RE: Addition, 190 Rand Road
ID #2004-0180, CBL #255-A-008

On October 1, 2004, the Portland Planning Authority approved a 2,500 sq. ft. addition to the existing Stultz Fluid Power building located at 190 Rand Road, with the following conditions:

SITE PLAN: BUILDING EXPANSION
STULTZ FLUID POWER
 OF:
PATCO CONSTRUCTION
 1293 MAIN STREET
 SANFORD, MAINE 04073

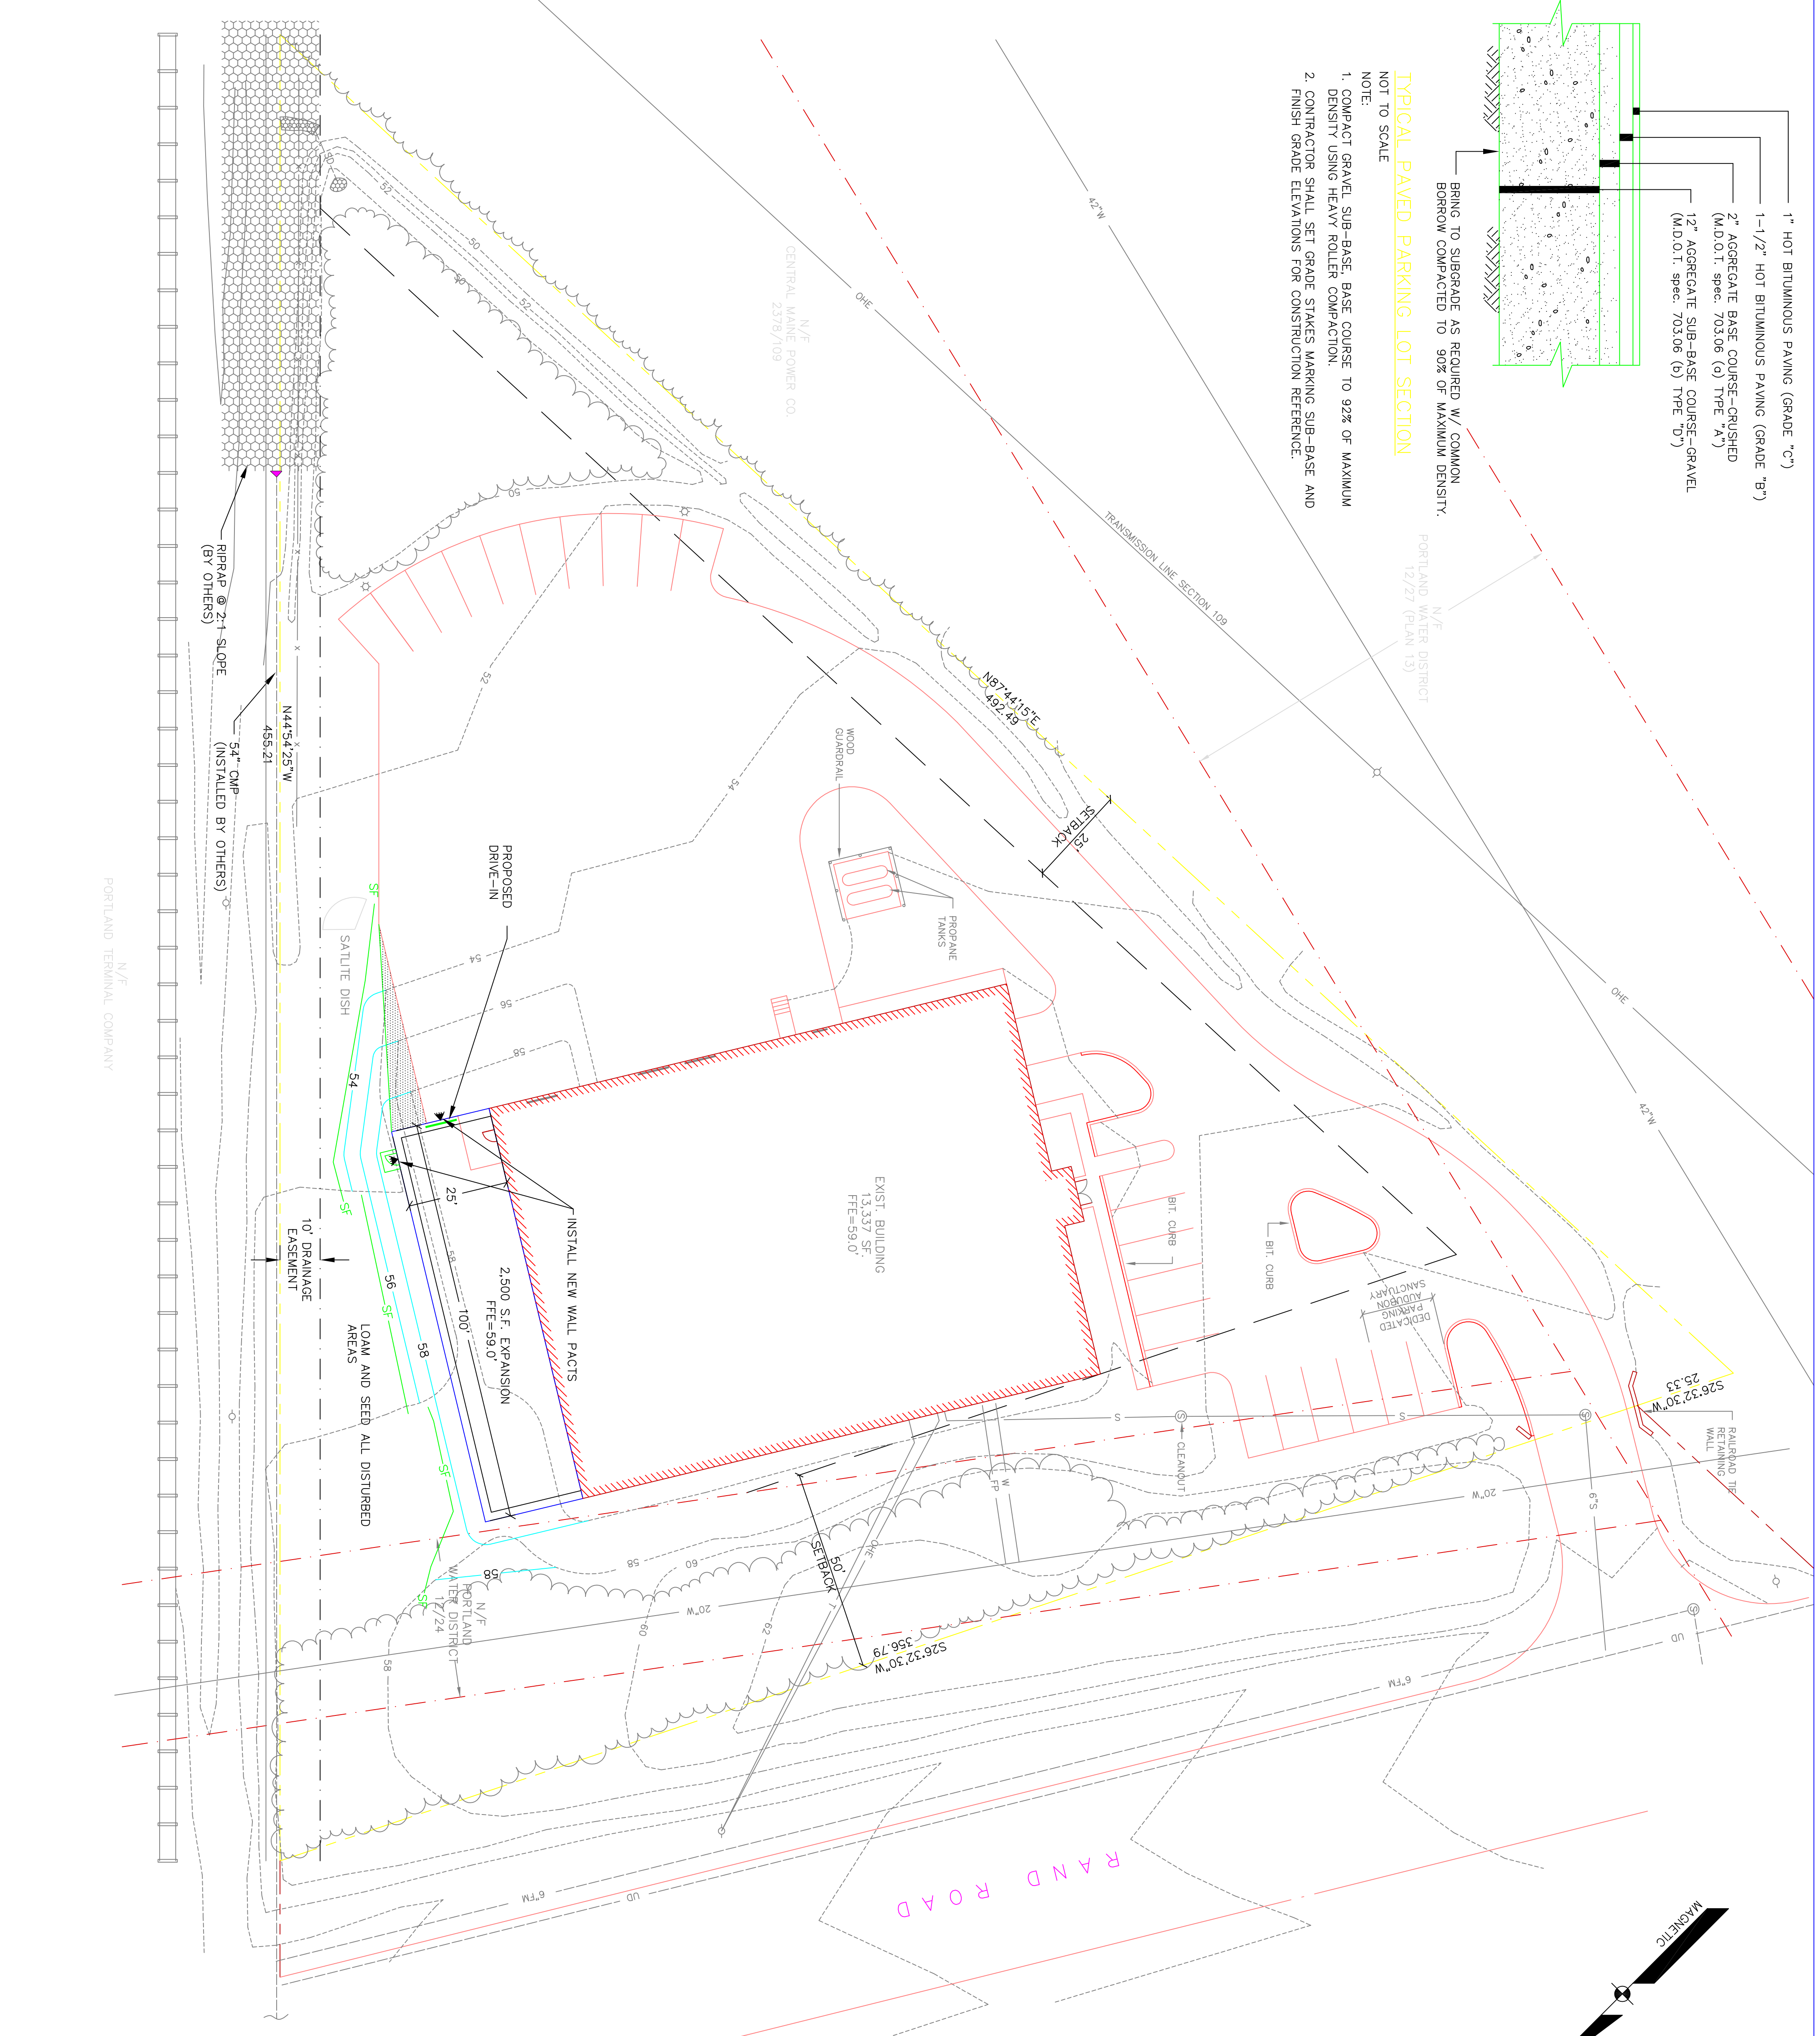
1. The silt fence should be continuous, not 3 separate sections. It should also wrap around the front of the building (Rand Road side) to envelope all limits of work.
2. It is recommended that the mature tree line be preserved through construction, and noted on the site plan.
